Your ref:	.	<b>Please reply to:</b>	<b>Mr Anthony Perera</b>
Our ref:	21/04179/ADV	Tel No:	07866034072
		Fee Queries:	0207 641 6500;
		Email:	planningreception@westminster.gov.uk;
Baha Arab  60 Crawford Street London W1H 4JS		<b>Incomplete Applications</b> Development Planning City of Westminster PO Box 732 Redhill, RH1 9FL	
		28 June 2021

TOWN AND COUNTRY PLANNING (CONTROL OF ADVERTISEMENTS) REGULATIONS 1992

**Address: 60 Crawford Street, London, W1H 4JS**

**Proposal: Display of a non illuminated fascia sign measuring 0.27m X 2.835m and non illuminated projecting sign measuring 1.12m X 1.1m**

1 Existing Ground Floor Plan
1:50 @ A2

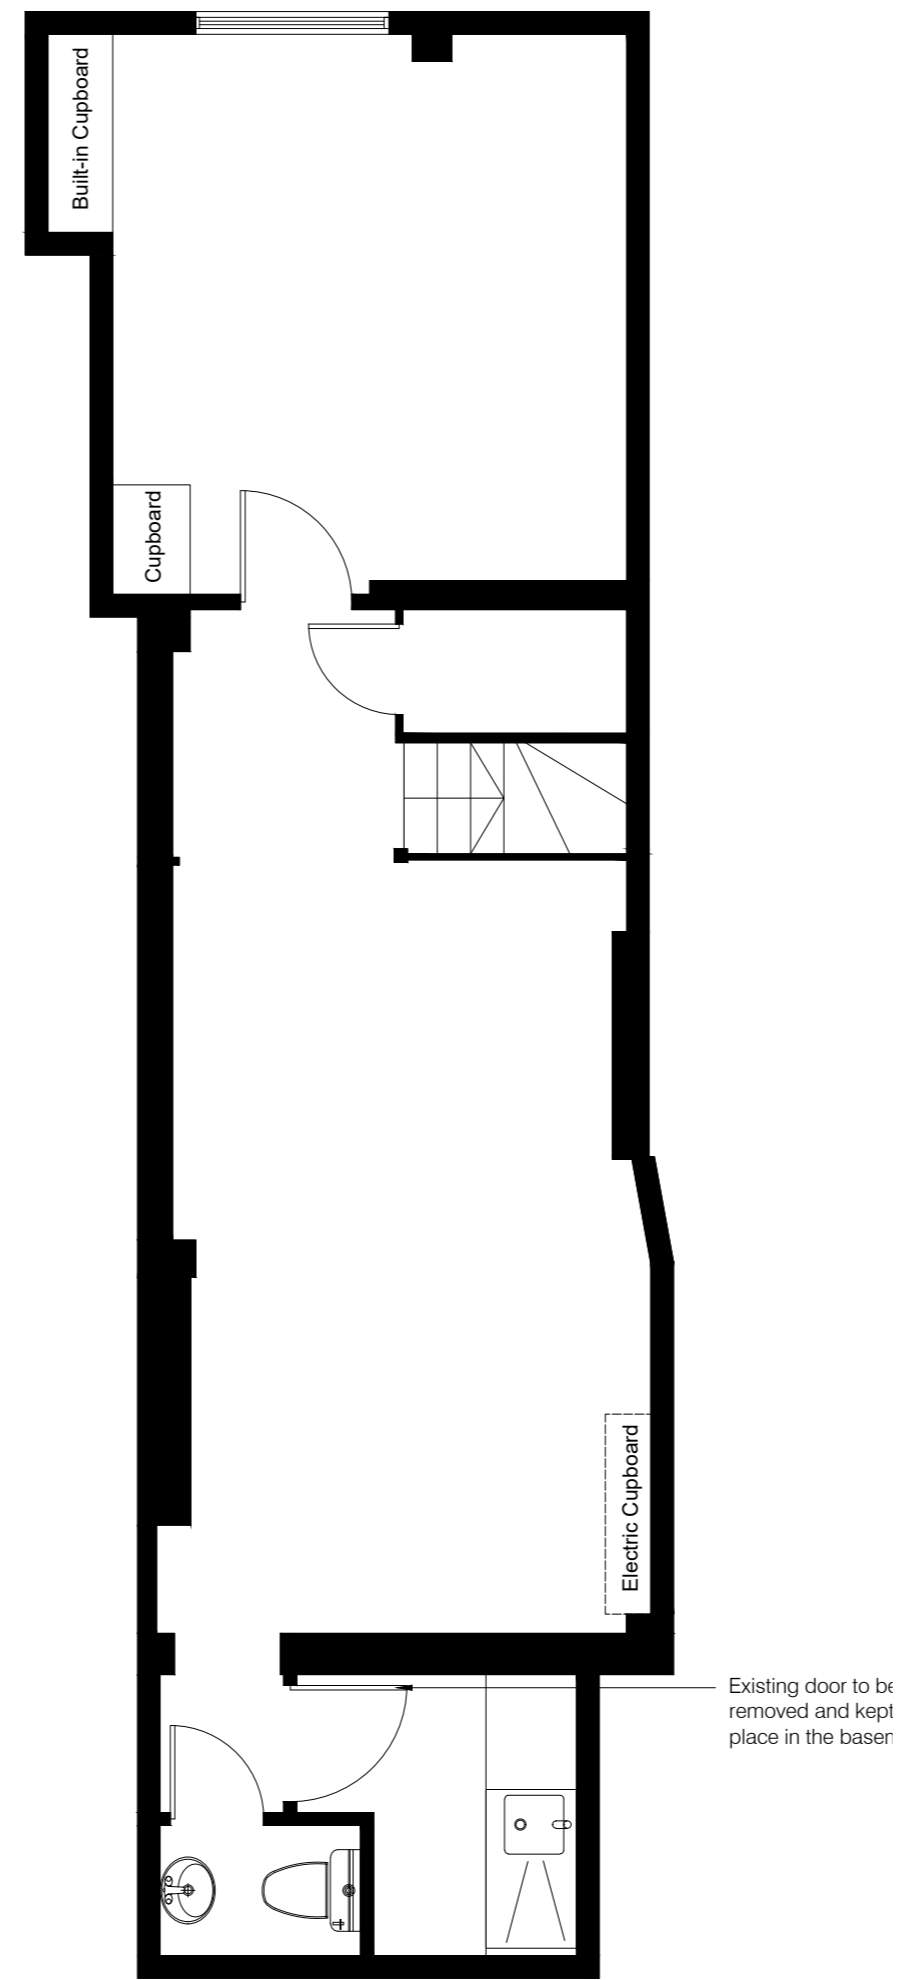
- 2 Some or all of the drawings submitted with your application do not include a scale bar, please amend. This is required as we have moved to an electronic way of working and no longer print paper copies of drawings.

1 Existing External Elevation  
NTS

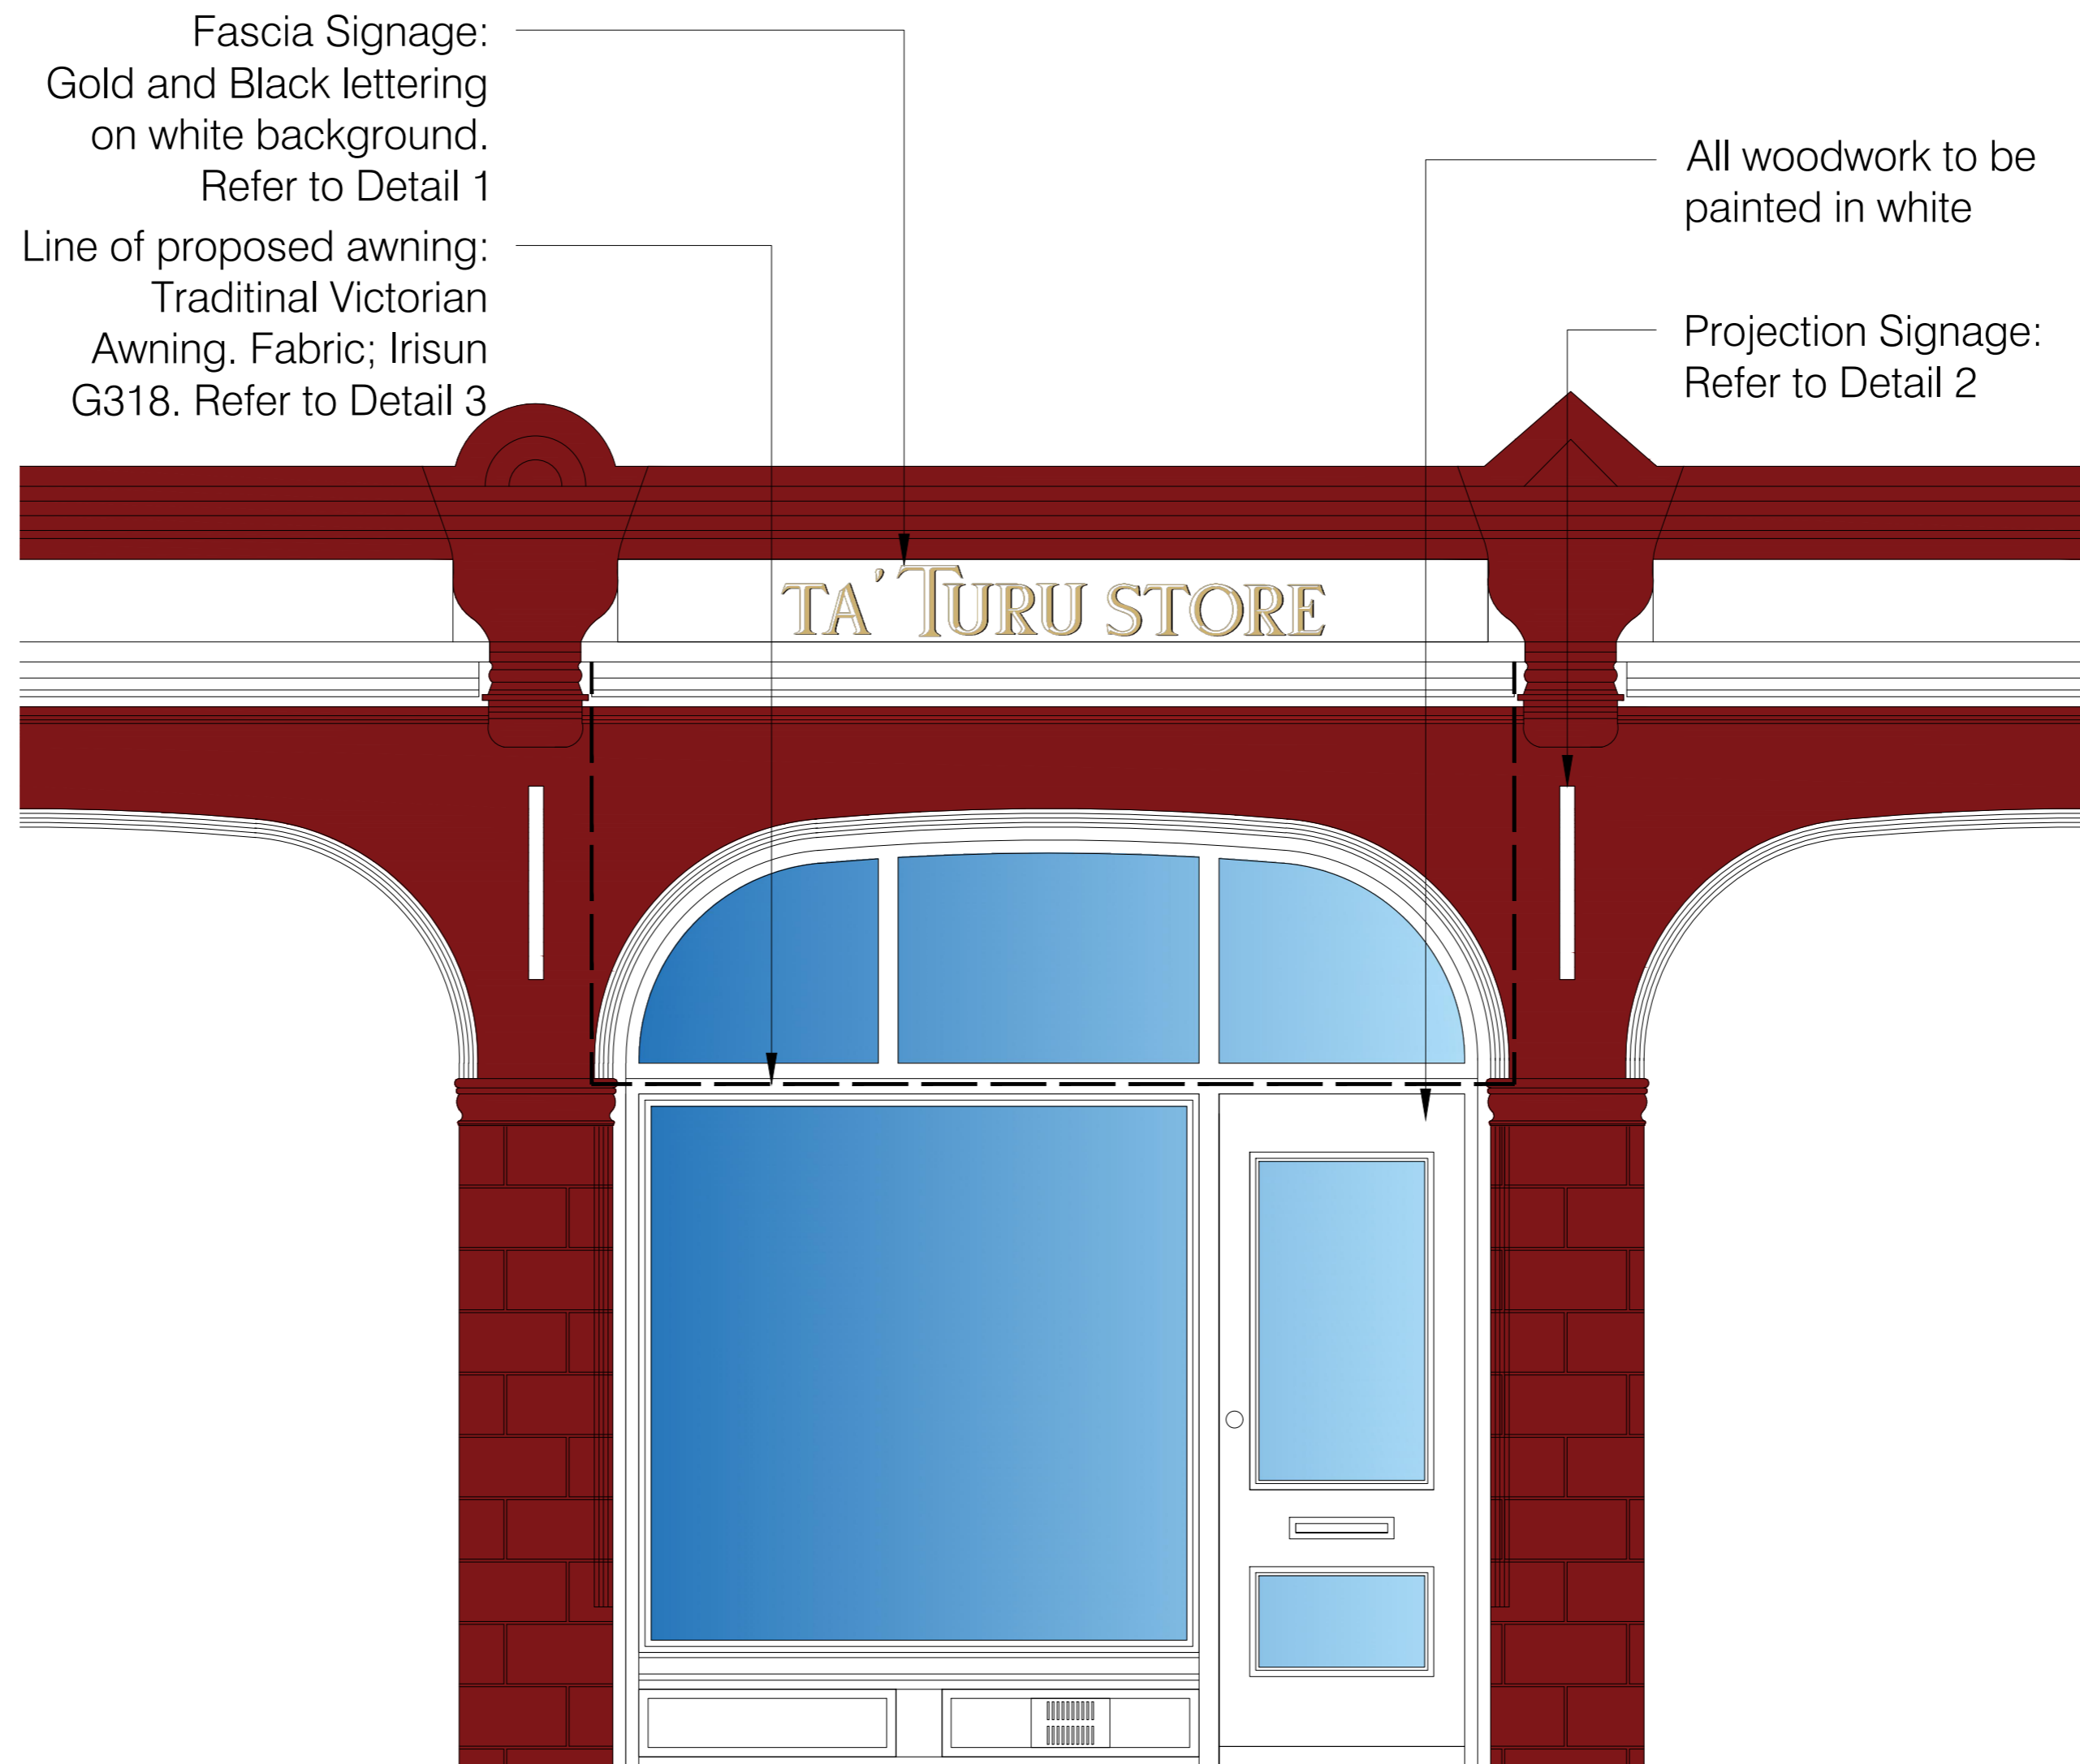
1 Please provide the following:

- existing front elevations
